Recommendation Report for Planning Permission for Works or Extension to a Dwelling

REF NO: FP/85/18/HH

LOCATION: 19 Davenport Road
Felpham
PO22 7JR

PROPOSAL: Single storey side extension. Resubmission of FP/300/17/HH

Existing and Proposed ground floor plans

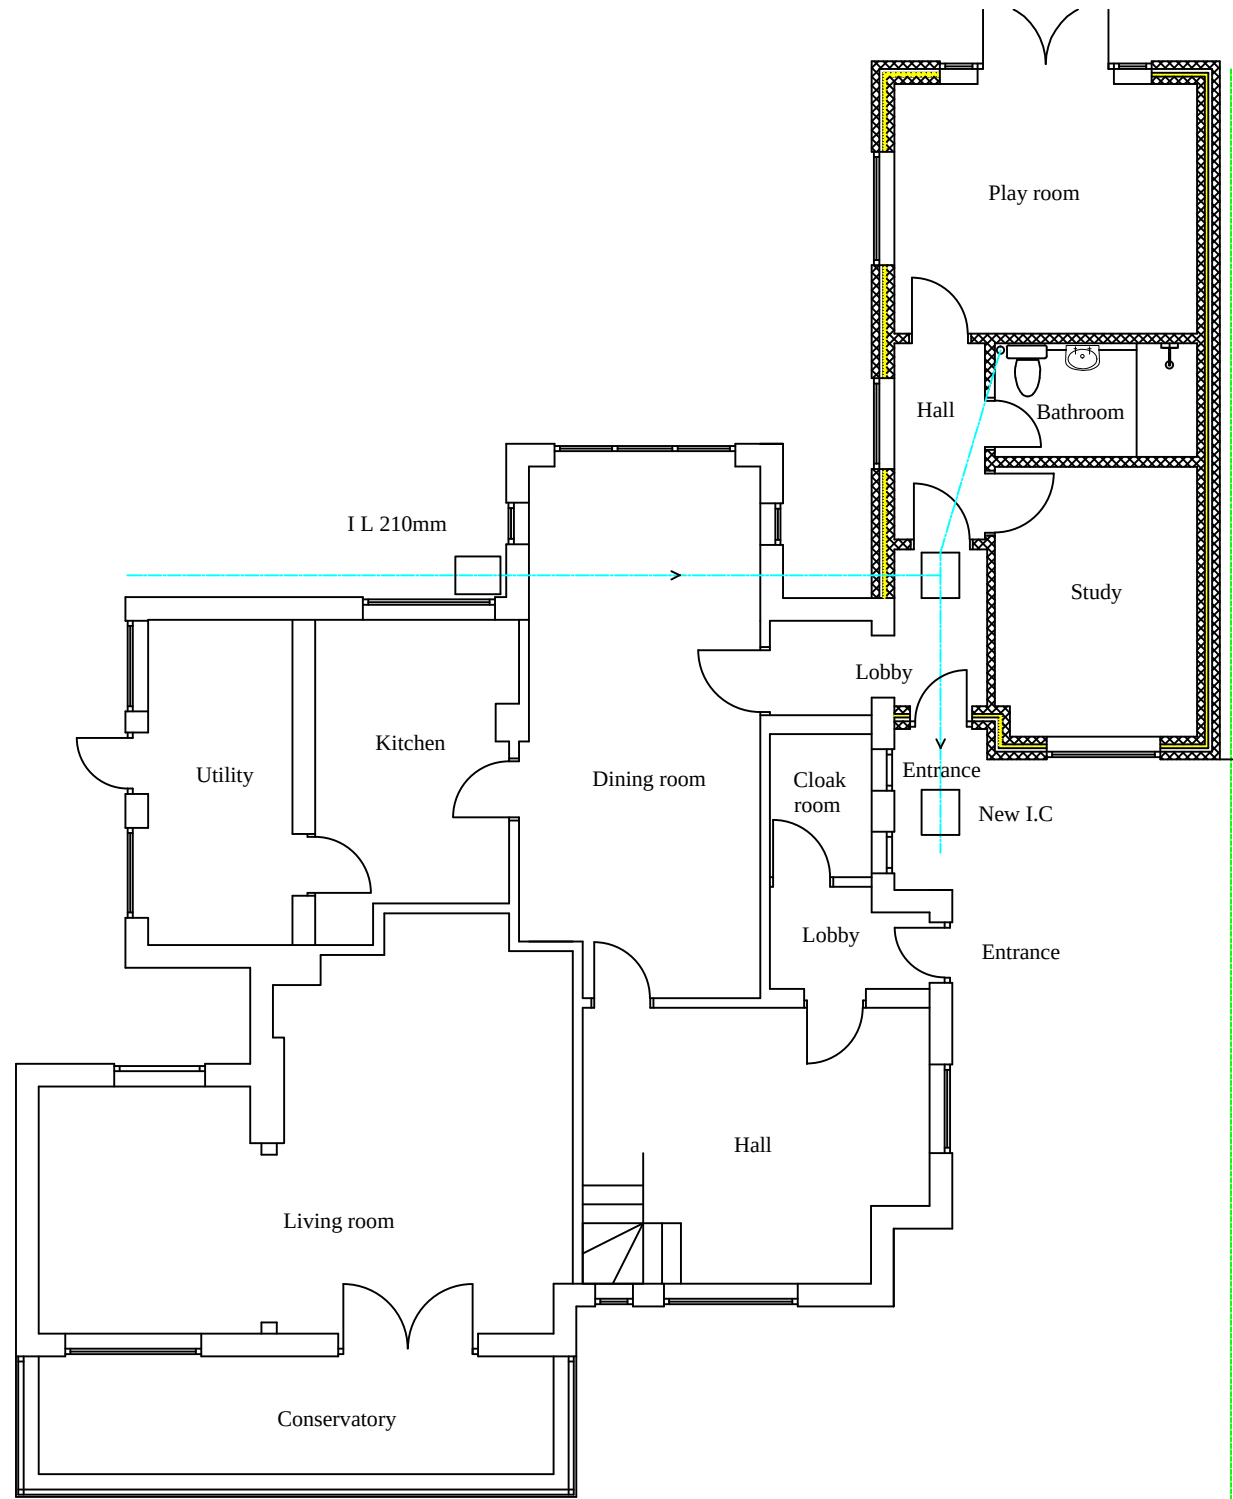
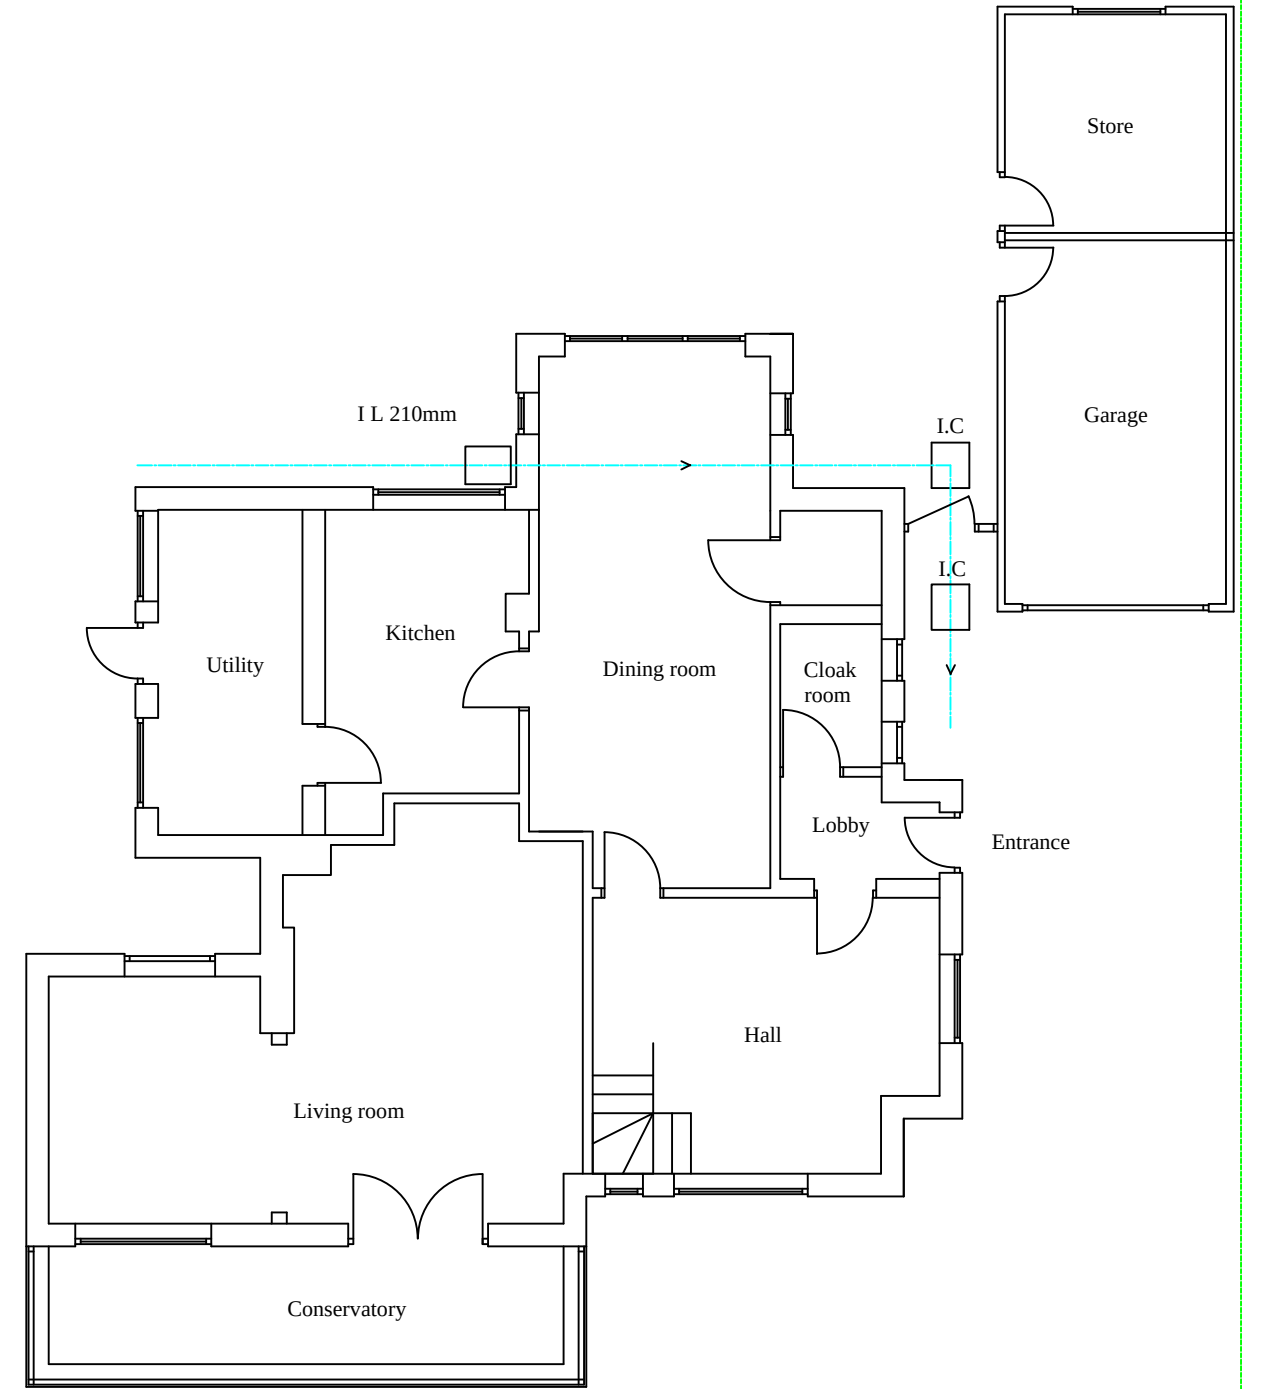
The proposed development will extend into the rear garden to around 9.2m in length which is around 1.2m longer than what currently exists and will be around 1.5m wider towards the western elevation. The eaves height is also increased by around 0.50m whilst the total height will remain the same with the roof pitch being altered.

There will be 2 windows to the western elevation which will overlook the rear garden and fencing and due to the separation distance of around 13m and the boundary treatment it is not considered to give rise to any loss of privacy or outlook. A proposed window to the rear of the development will overlook the rear garden of the property.

The proposed extension is built close to the boundary line to the east with a separation of around 0.1m. The proposed extension is slightly larger than what currently exists however it is not considered to be significantly different in size and the overall height would remain the same and therefore it is considered there will be no greater impact on the neighbouring property than the existing single storey garage/store. The proposed development is not considered to give rise to any unacceptable adverse overbearing, overshadowing or overlooking impacts upon the neighbouring residential amenity and accord with GEN7 and DEV19 of the Arun District Local Plan.

PROJECT	Proposed Single Storey Side Extension 19 Davenport Road Felpham PO22 7JR		
TITLE	Proposed Elevations		
CLIENT	Mr & Mrs Dave Vawdrey		
SCALE	1: 100	DATE	20/11/2017
DRAWING NO.	908-03	rev.	28/03/2018

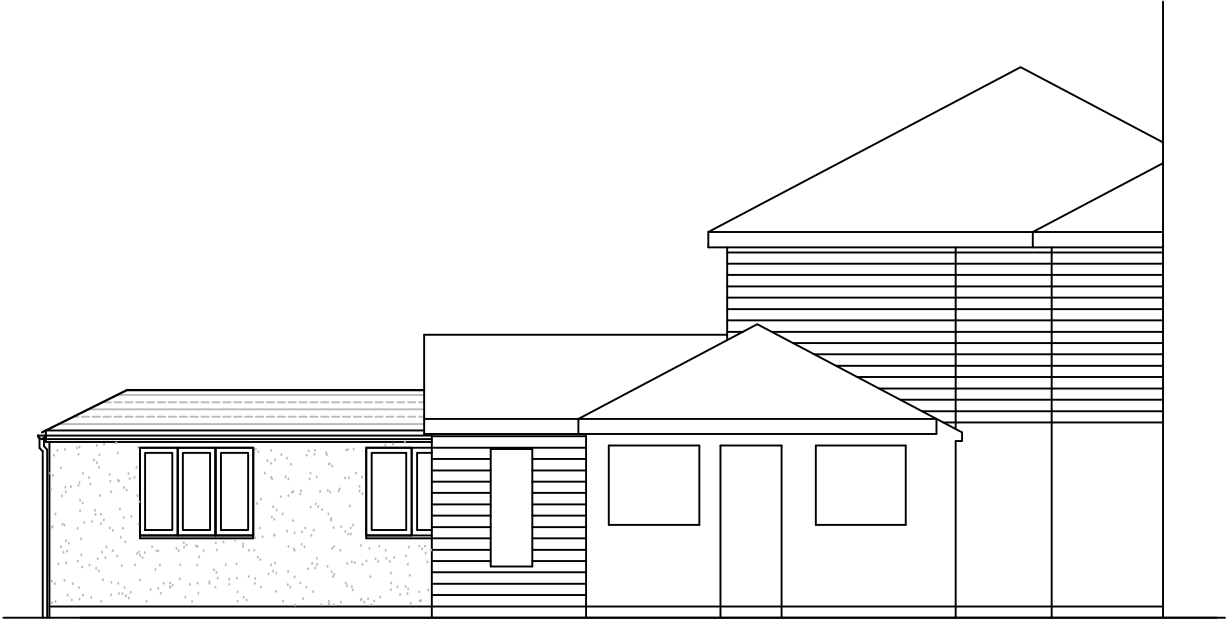
A previous application FP/300/17/HH was refused due its size and it being unduly dominant to the neighbouring occupants. This application addresses some of the size issues by reducing the length of the proposed development from 11m to 9.2m. The height of the proposal is also reduced from 4.3m to 3.1 which matches the height of the existing garage.

The proposed extension would be sited to the eastern side of the house and would be visible from the street scene. It sits approximately 12m from the front boundary of the property and will replace the existing structure and will be of materials to match the existing dwellinghouse.

With the total height of the extension remaining the same as what currently exists it is not considered unduly dominant and it is therefore not considered to have any unacceptable adverse impacts upon the spatial pattern or character of the area and accord with DEV19 and GEN7 of the Arun District Local Plan and ESD1 of the Felpham Neighbourhood Plan.
